Please ask for: Nicola Moore
Email: nicola.moore@arun.gov.uk
Telephone: Ext 37944
Our Ref: AW/80/22/T
Your Ref:
Date: 25th March 2022

Application for Works to Trees(s) subject to a Tree Preservation Order(TPO)

Development: 1 x Monterey Pine -fell due to weakened trunk from large branch falling in the storm of the 18.2.22. Marked 03007 on said plan.
1 x Monterey Pine - raise canopy by 3 metres. Marked 03008 on said plan
1 x Monterey pine - remove deadwood in crown. Marked on 03009 on said plan.
Location: Malmayne Court Aldwick Fields Aldwick PO21 3SW

Fig 4 T30008 Remove two lowest whorls of branches

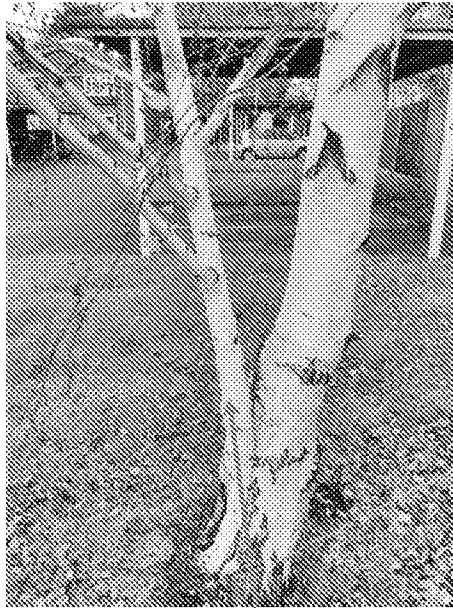
1 No. Monterey Pine (03008) - please provide the height above ground level to wish to lift the crown eg. lift crown to 1m above ground level.
